**Camden Valley Medical Campus
Gledswood Hills**

Concept Development Access Review

Morris Goding Accessibility Consulting

6 July 2016

BASEMENT FLOOR PLAN

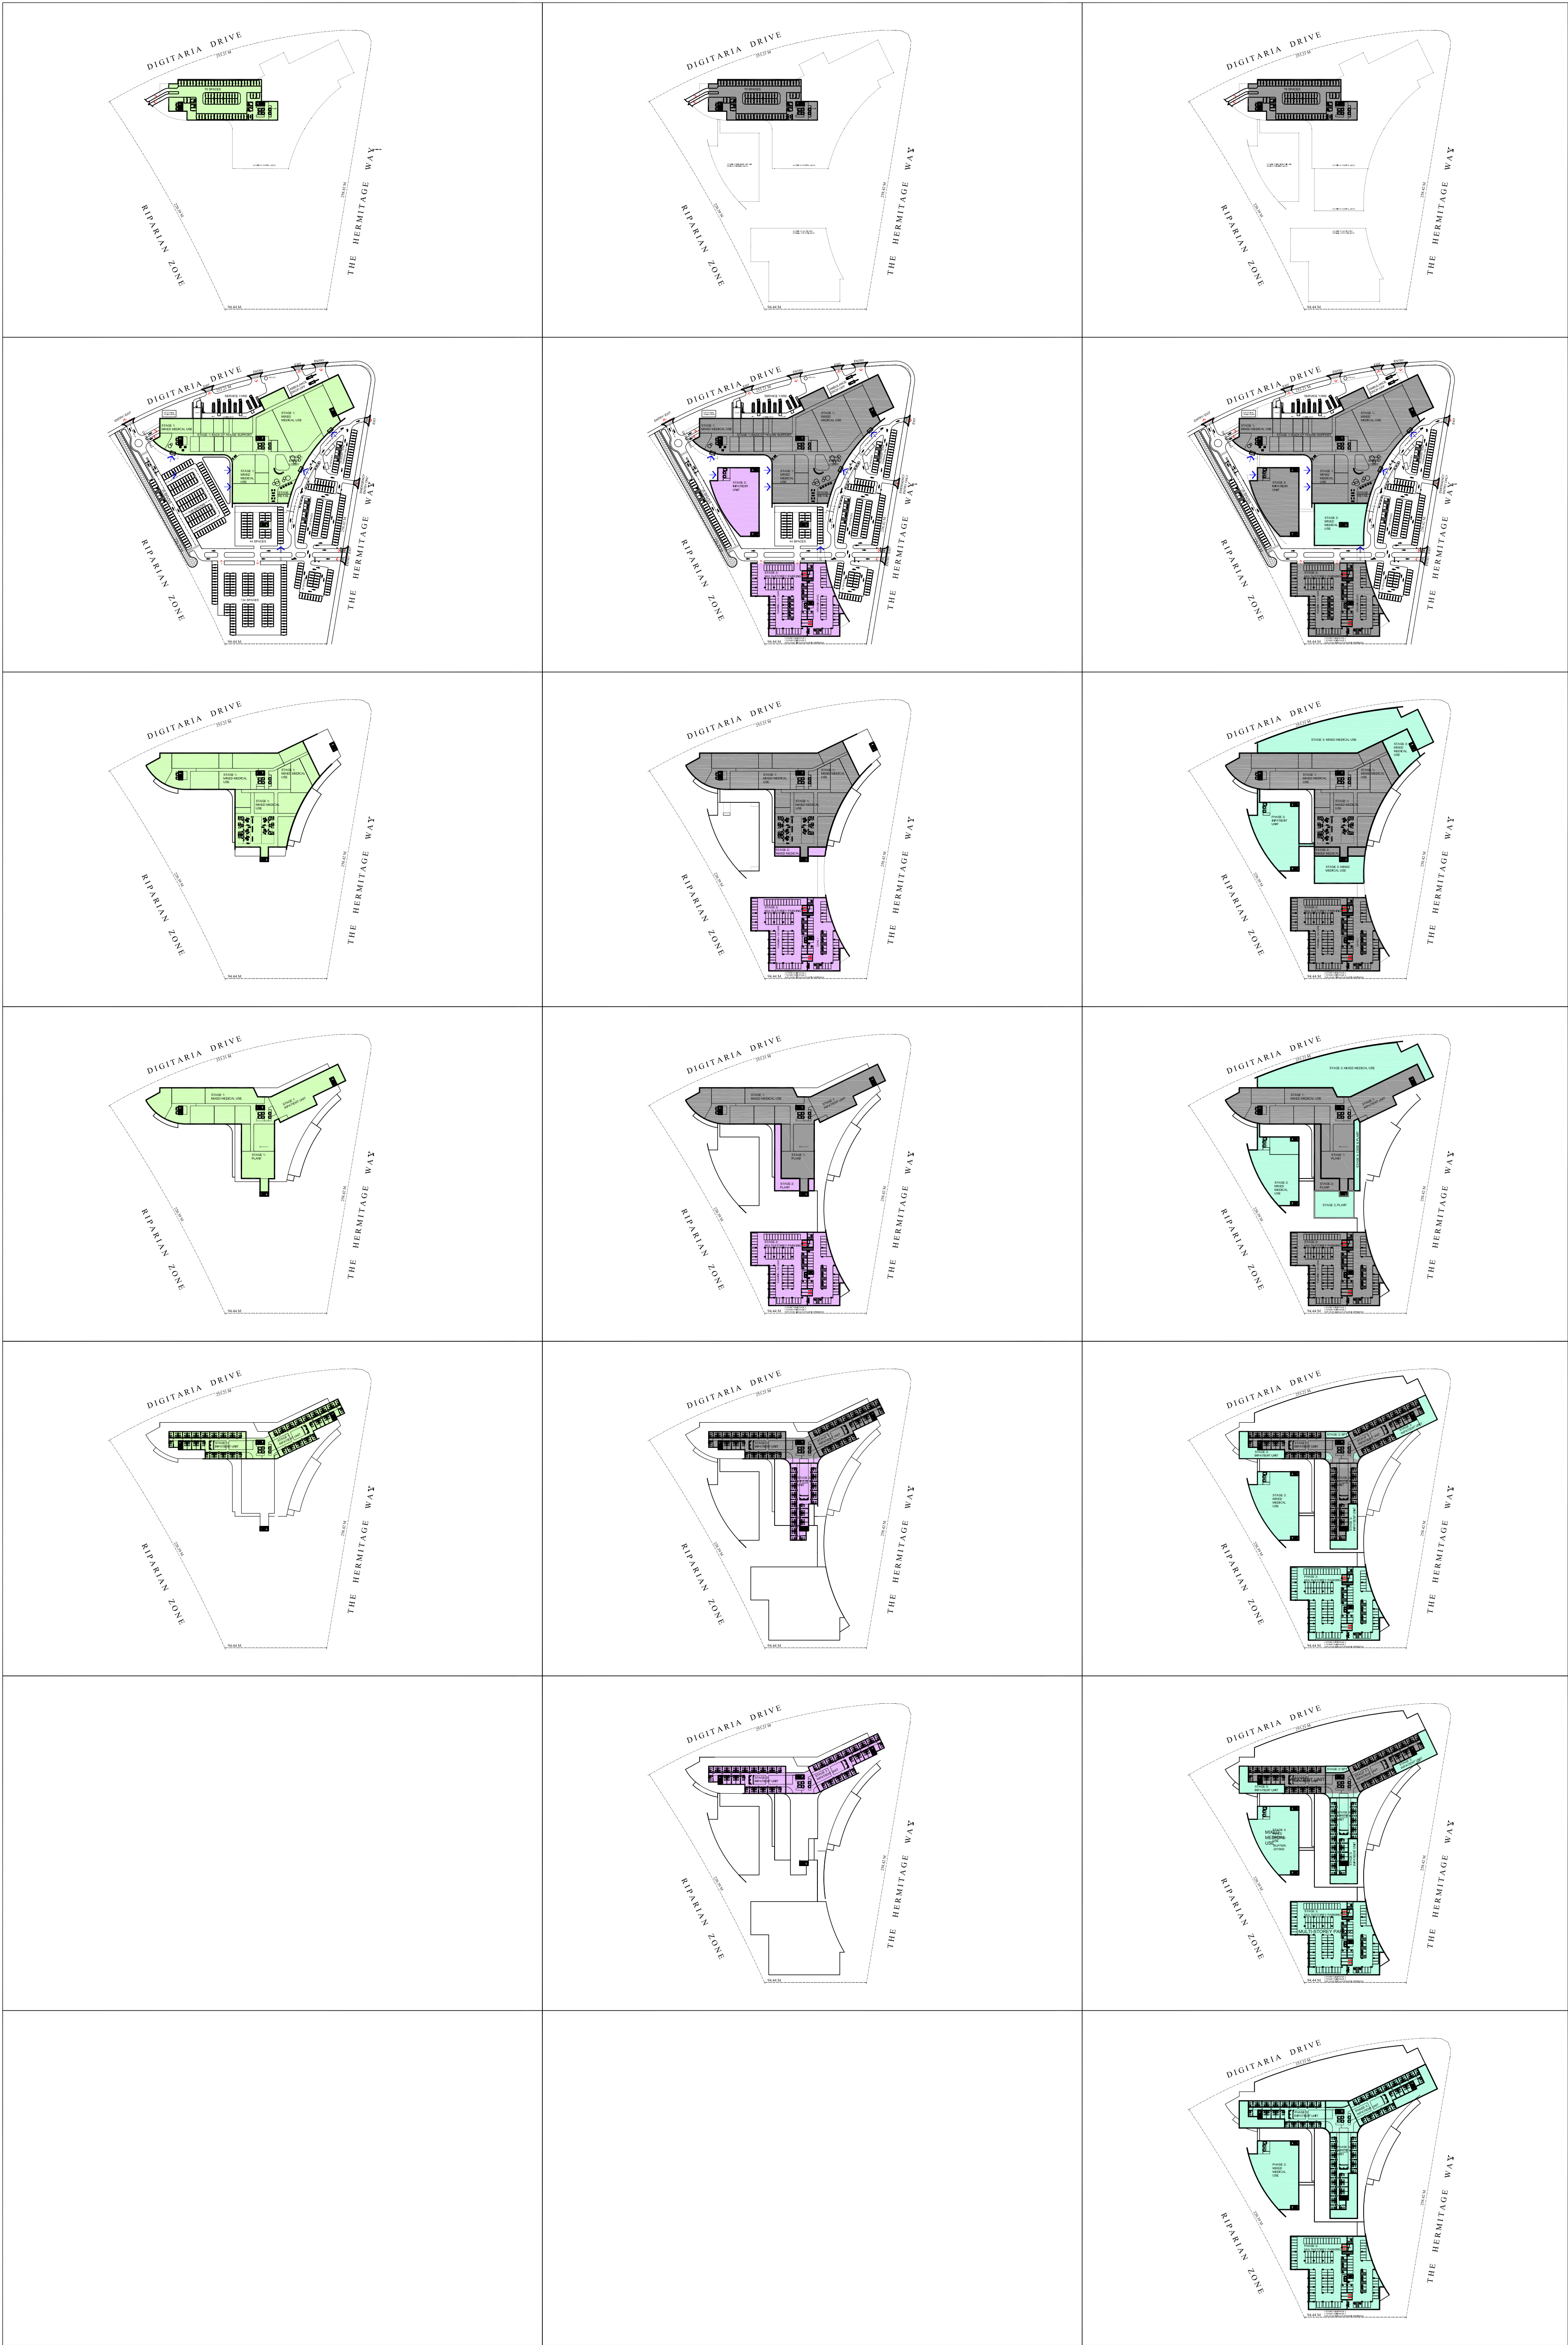
The concept drawings identify 6 entrance points into the main hospital building:

- directly into the Emergency Department,
- directly into the Main Lobby,
- from the direction of the multi-storey car park,
- into the area identified as “Mixed Medical Use”,
- adjacent to the Mixed Medical Use entrance
- into the area generally identified as “back of house support”.

The main building is in excess of 500 m² hence 50% of entrances must be accessible; however, any non-accessible entrance must not be located further than 50 metres from an accessible entrance. From the concept plan provided only the entrance to the “Mixed Medical Use” area and the adjacent entrance are within 50m of each other. One of those entrances must be accessible. All other entrances identified must be accessible.

The in-patient areas of the main building have indicatively 2000mm wide corridors

The car park building does not indicate a dedicated path of travel from the accessible car parking spaces to the lifts, or from the lifts to the pedestrian connection/entrance to the main building. Rather the accessible path of travel is in common with the vehicle circulation system.

The stand-alone building which is titled for use as (“In-Patient” for stage 2, then “Mixed Medical use” for stage 3) is not provided with an indicative layout.

There appears to be a ramp indicated between half-levels in the car park adjacent to the vehicle ramps furthest from the lifts. This ramp is two car parks long (hence approx. 11m). At 11 m without a landing, the maximum gradient permissible is 1:16. An 11m ramp at grade 1:16 will rise only some 685mm. If the half-levels of the car park are evenly spaced vertically, this will not be sufficient rise.

It is noted that the upper level served by this ramp is not provided with any accessible car parking spaces. Should this ramp be provided for uses other than providing an accessible path of travel (eg for pram users), it is noted that National Construction Code Series Building Code of Australia clause D2.10 limits the gradient of this ramp to a maximum of 1:8. It is also recommended that signage be provided to indicate the ramp is not intended for wheelchair users.

- (i) Ensure there are no non-accessible entrances further than 50m from any accessible entrance, and
- (ii) Ensure all accessible entrance have doorways that provide: appropriate clear opening width, sufficient circulation space to approaches on both sides of the door for wheelchair manoeuvring, appropriate door furniture including automatic closers with complying door operating forces.

- (i) Provide signage to indicate function of ramp (ie not for use by wheelchairs).
